**HINCKLEY NATIONAL
RAIL FREIGHT INTERCHANGE**

**Sapcote Technical Note [Appendix 2 (B) -
Additional Information Provided to Auditor
and Auditor Response]**

Stage 1 Road Safety Audit
RESPONSE REPORT (SAPCOTE ONLY)

24-1363.09-RSA1 – B4669 Leicester Road, Sapcote

Proposed Layout - School buses waiting in loading bay in front of Co-Op

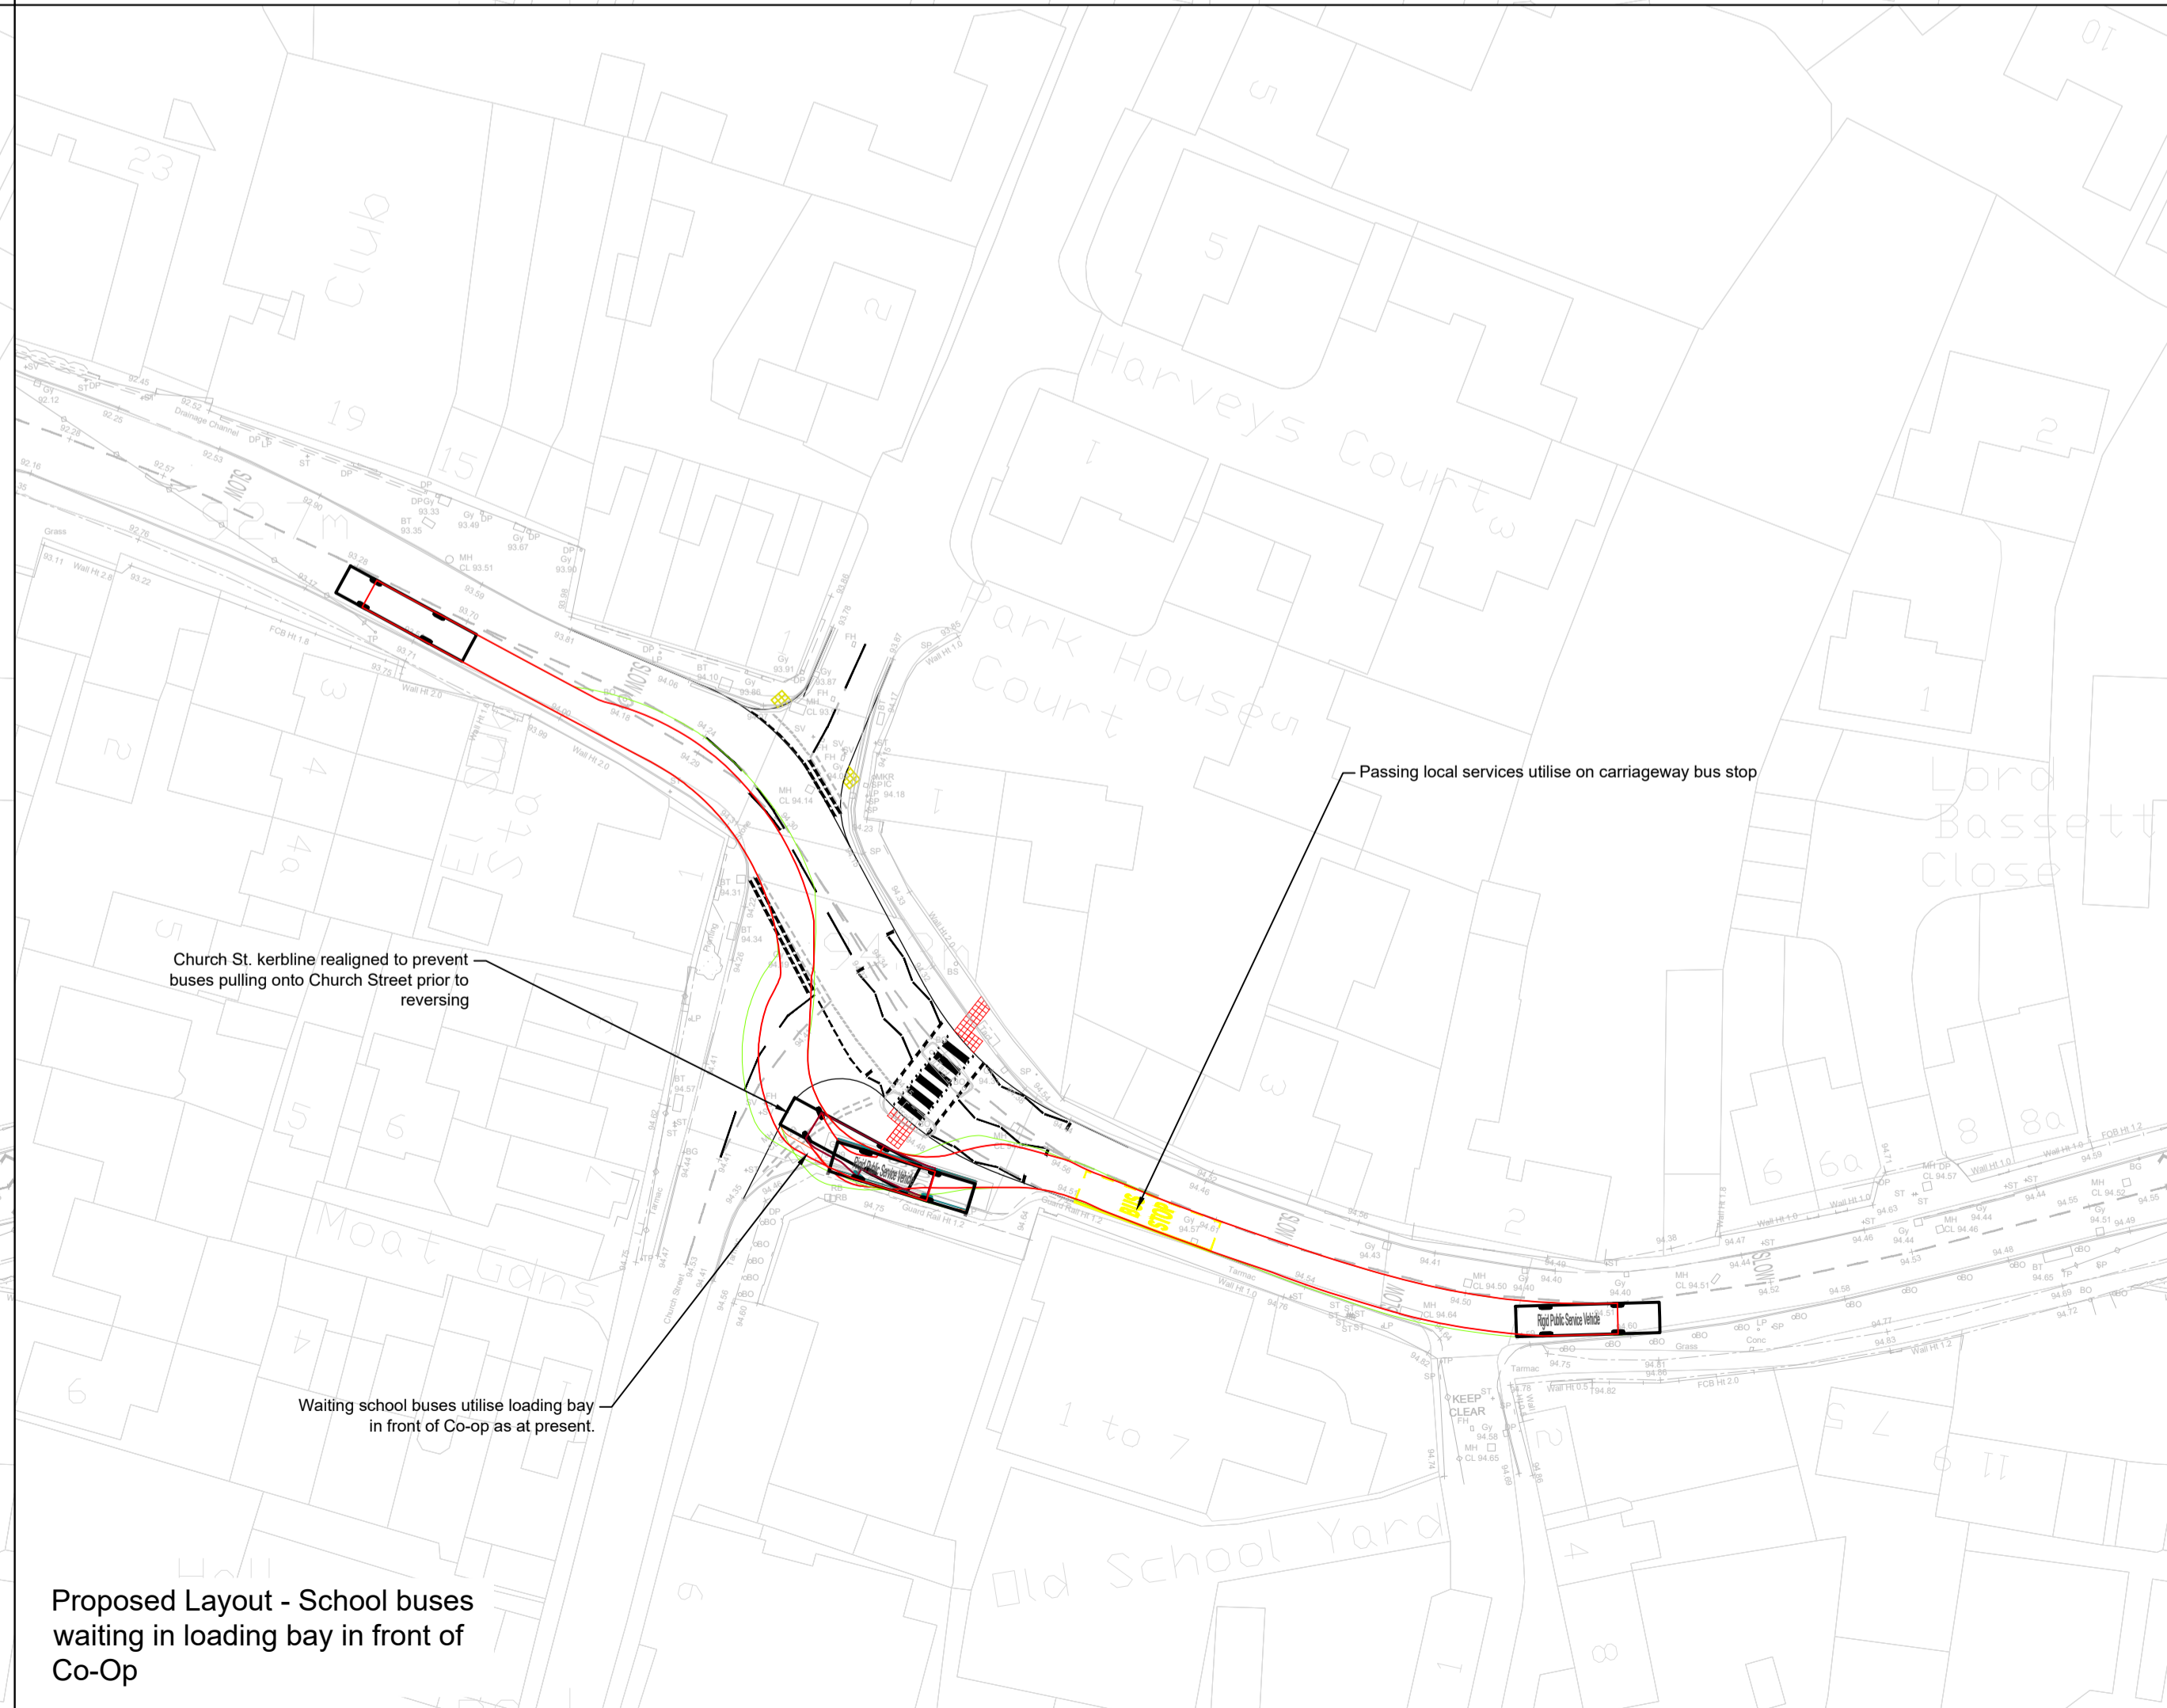
RSA Ref.	RSA Problem and Recommendation	Design organisation response	Auditor Response	Agreed RSA action
	<p>Location: Leicester Road - proposed bus stop / loading bay within "shared space" footway. Summary: School bus movements within the footway risk vehicle to pedestrian collisions.</p> <p>Under the existing layout school buses and delivery vehicles are able to pull into the lay-by in front of the Co-op. Whilst the intention is to maintain this existing situation, the changes to the layout here mean that the current lay-by will effectively become (and resemble) footway. This change is likely to result in pedestrians, specifically school children, waiting over a wider area as opposed to being concentrated within the footway when waiting for and alighting from the school bus. There is a concern that this will increase the risk of vehicle to pedestrian collisions, particularly given the complex manoeuvre required to fully enter the bay.</p> <p>Recommendation: It is recommended that an alternative route / provision is created for the school bus stop/loading bay which may require a wider and more considered approach and not one that simply attempts to mirror existing circumstances.</p>	<p>Agree with RSA recommendation: In Part</p> <p>The designer agrees that careful consideration is required regarding the demarcation of any shared surface in this area with suitable tactile and contrasting coloured paving to clearly identify the areas for vehicle use.</p> <p>The Co-op have a service area in their car park on Church Street but the designer were advised by the overseeing organisation that this area is currently used by vehicles servicing the Co-op. It should be noted that it is contrary to traffic regulations for service vehicles to use the existing bus stop, however provision was made in the proposed design, utilising shared surfacing for the delivery vehicle to use this areas in the event that the overseeing organisation elects to amend the relevant traffic regulations.</p> <p>While the majority of passing bus services will use the on carriageway stop (provided on the B4669 as part of the HNRFI works), the overseeing organisation also advised that school bus services currently stop in this area. The swept path movement for buses using the area will be the same as it is currently as the area available is the same. It is the designer's view that the careful use of tactile paving, small kerb upstands and contrasting paving in this location can enable the area to be utilised successfully as a shared surface and to allow buses and school children to wait safely without coming into conflict with each other.</p>	<p>The Audit Team have reviewed the amended design incorporating tactile paving, the use of a darker material within the area used by vehicles and a 50mm splay kerb to the access / egress for the area as shown in drawing HRF-BWB-HGN-HW18-DR-CH-101 rev P01.</p> <p>It is felt that this approach largely mitigates the concerns raised in the RSA1 and will likely deter some of the existing improper use of the space by the general public.</p> <p>It is recommended that appropriate signing to highlight the restricted use of the space is incorporated into the detailed design.</p>

**SAPCOTE ENHANCED
SCHEME
VISIBILITY TO
PEDESTRIAN CROSSINGS**

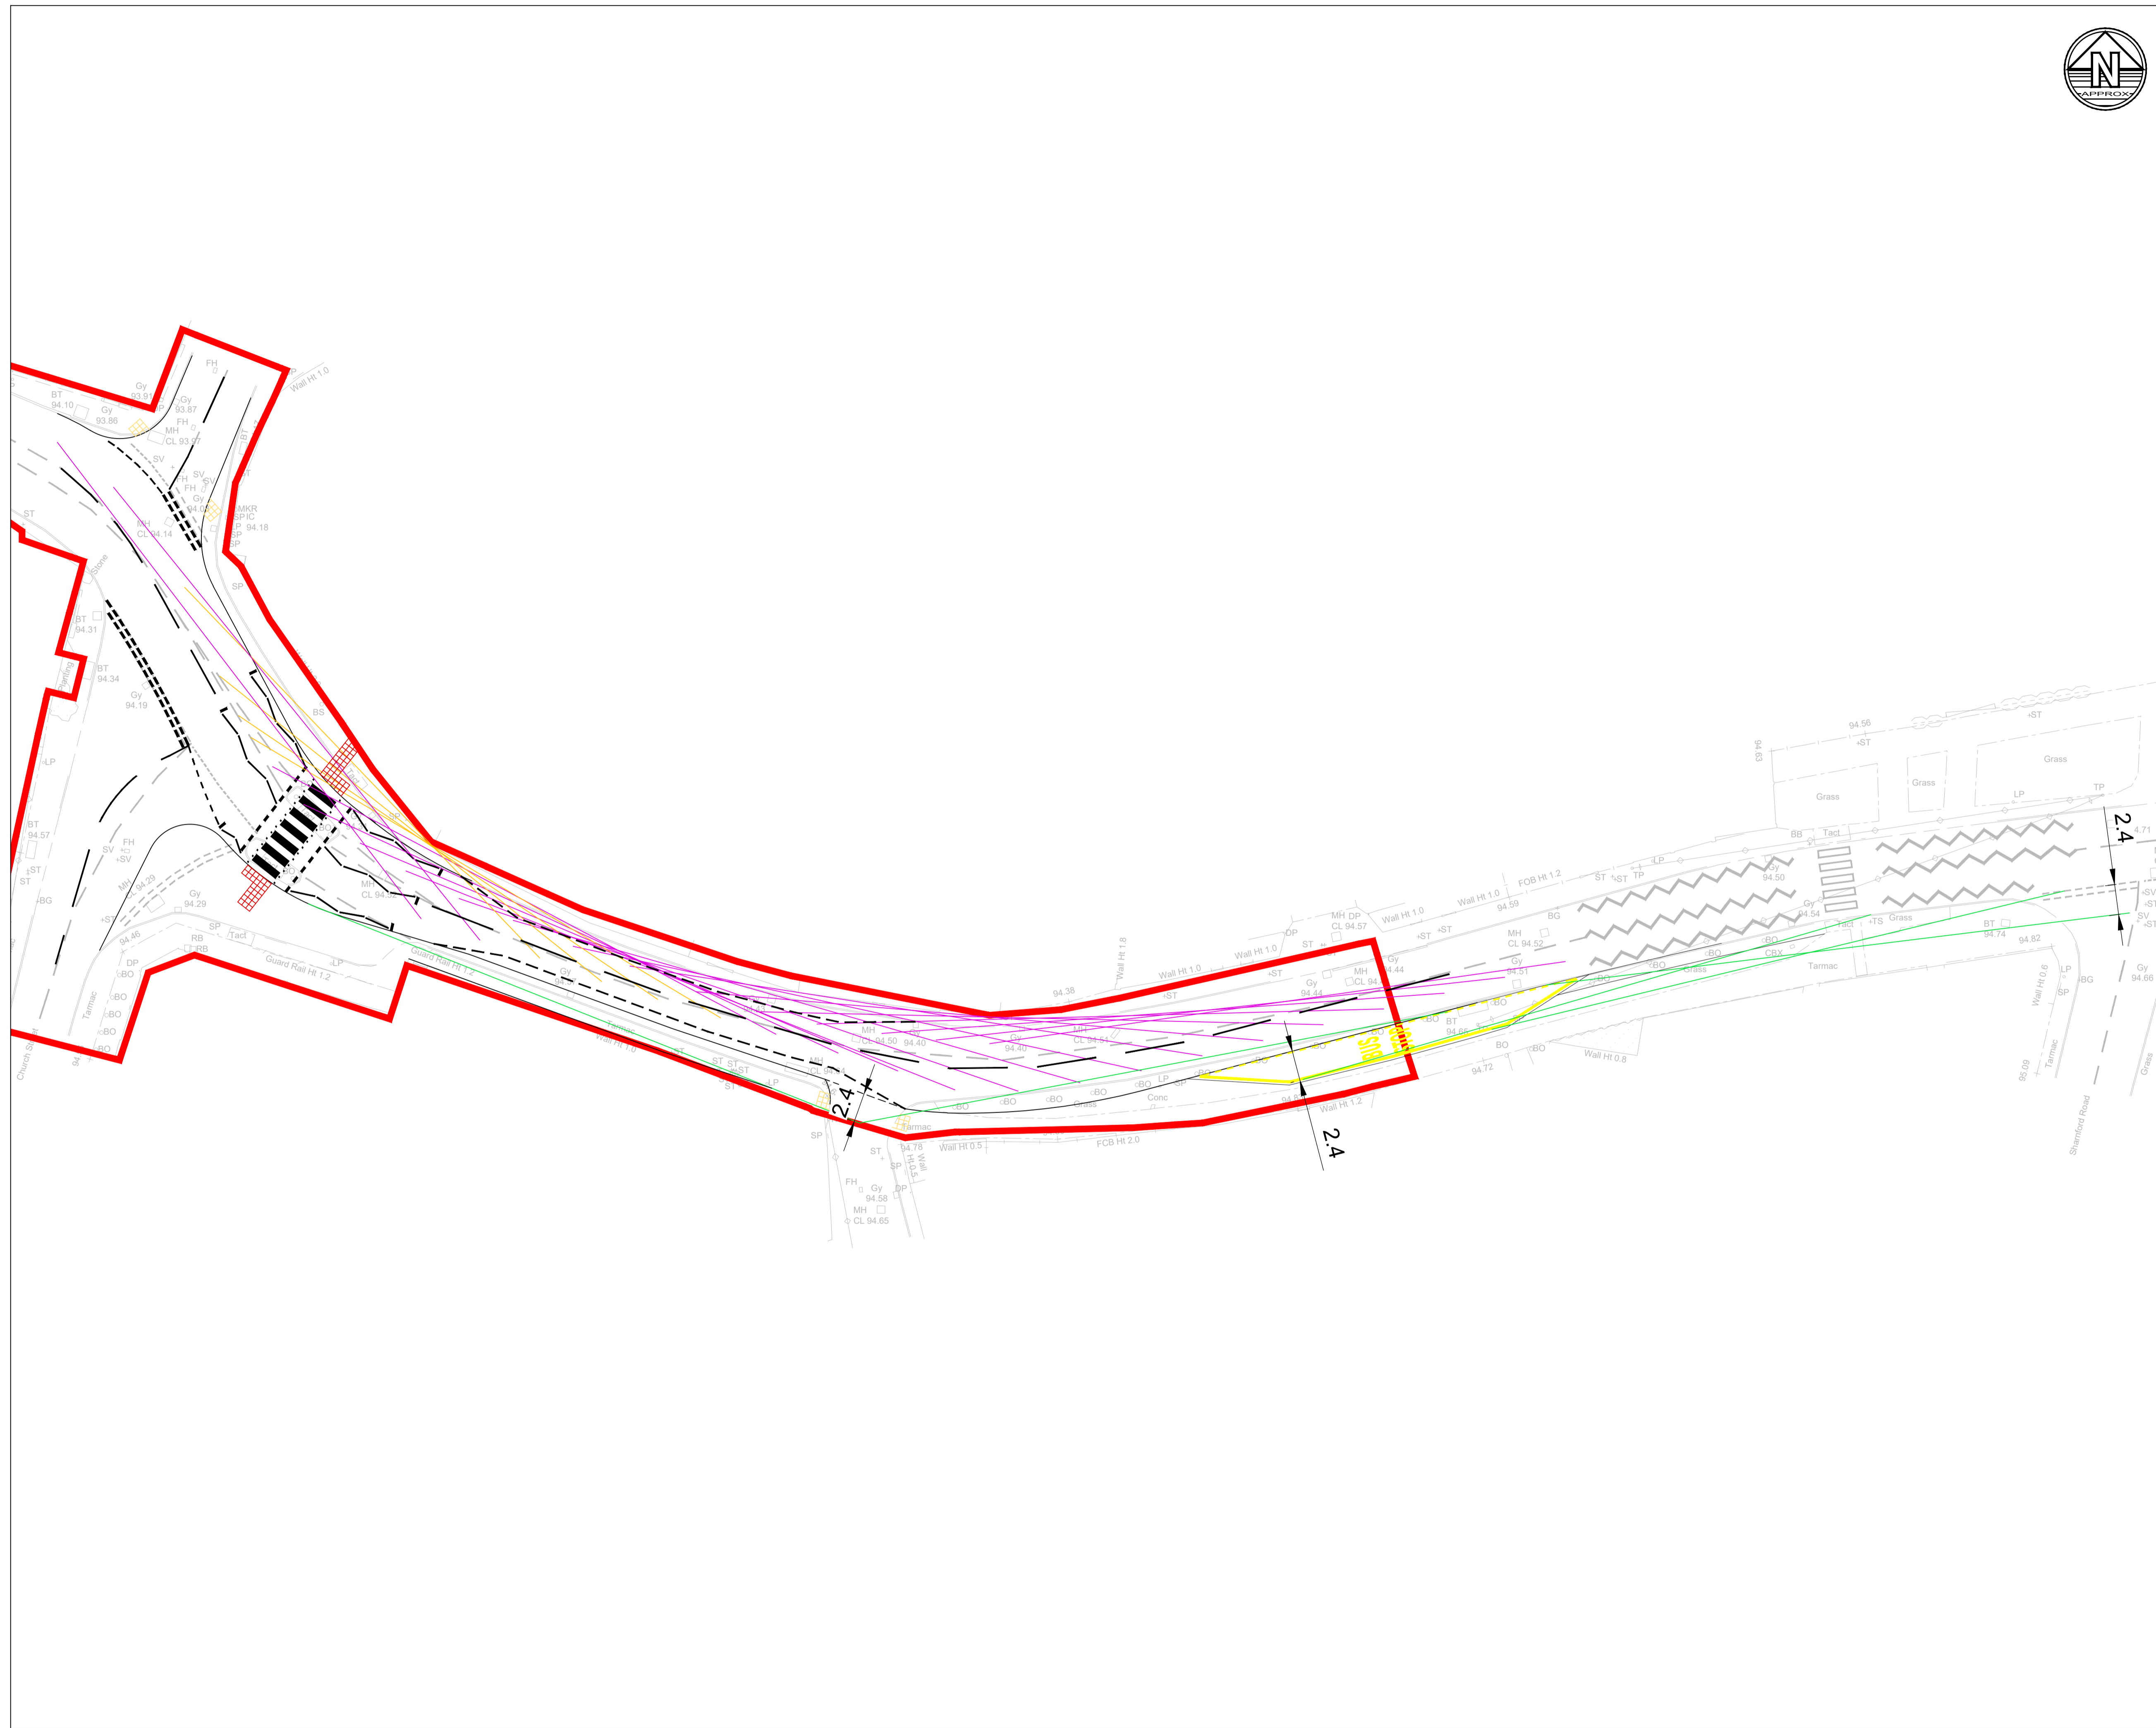
RSA Ref.	RSA Problem and Recommendation	Design organisation response	Auditor Response	Agreed RSA action
	<p>Location: Leicester Road - proposed Zebra crossing.</p> <p>Summary: Restricted visibility risks vehicle to pedestrian collisions.</p> <p>Whilst it is appreciated that visibility splays for pedestrians crossing north to south are included in the design, they have been measured from the kerb edge. For most users, especially pushchair and wheelchair users who's viewpoint will be set back from the edge of the footway, visibility for and of these users crossing or waiting to cross is restricted to the east by the building line and boundary wall of the adjacent properties. Should pedestrians enter the carriageway when unsafe to do so there is a risk of vehicle to pedestrian collisions.</p> <p>Recommendation: It is recommended that unobstructed pedestrian visibility commensurate with measured vehicle speeds is provided at the crossing point and that this is measured from an appropriate setback from the kerb edge.</p>	<p>Agree with RSA recommendation: Yes</p> <p>Measured 85th percentile vehicle speeds through this area of Sapcote are 23.5mph westbound and 21.9mph eastbound. At this crossing, the most constrained visibility splay is from the northern kerb line to westbound traffic due to the boundary wall which forms the highway boundary here.</p> <p>There is no specific guidance in LCC's Design Guide, nor Traffic Signs Manual Chapter 6 for measurement of a suitable set-back at a pedestrian crossing. Traffic Signs Manual Chapter 6 Table 15-1 recommends a minimum of 31m stopping sight distance for 85th percentile speeds up to 25mph. 31m visibility to westbound traffic from the northern kerb line is achievable at a set-back of 1.2m.</p> <p>LCC's Design Guide does not give specific crossing visibility requirements but Table DG4 provides guidance on visibility distance at junctions, bends and vertical crests. For 85th percentile speeds from 21 to 25mph the requirement is 33m for light vehicles and 36m for heavy vehicles. 36m visibility is achievable to westbound traffic from the northern kerb from a set-back of 0.8m.</p> <p>In other directions visibility exceeding those set out here is achievable from a set back of 1.2m.</p> <p>The set-back distances and visibility distances set out above are considered to be suitable for pushchair and wheelchair users and the designer believes that suitable visibility to the crossing is achievable.</p>	<p>The Audit Team have reviewed the amended drawing HRF-BWB-HGN-HW18-DR-CH-0110 rev P01.</p> <p>This now shows that visibility, in line with 85th percentile speeds and from an appropriate set back on the crossing, is achievable.</p> <p>The Audit Team are therefore satisfied that the problem raised within the RSA1 is no longer applicable.</p>
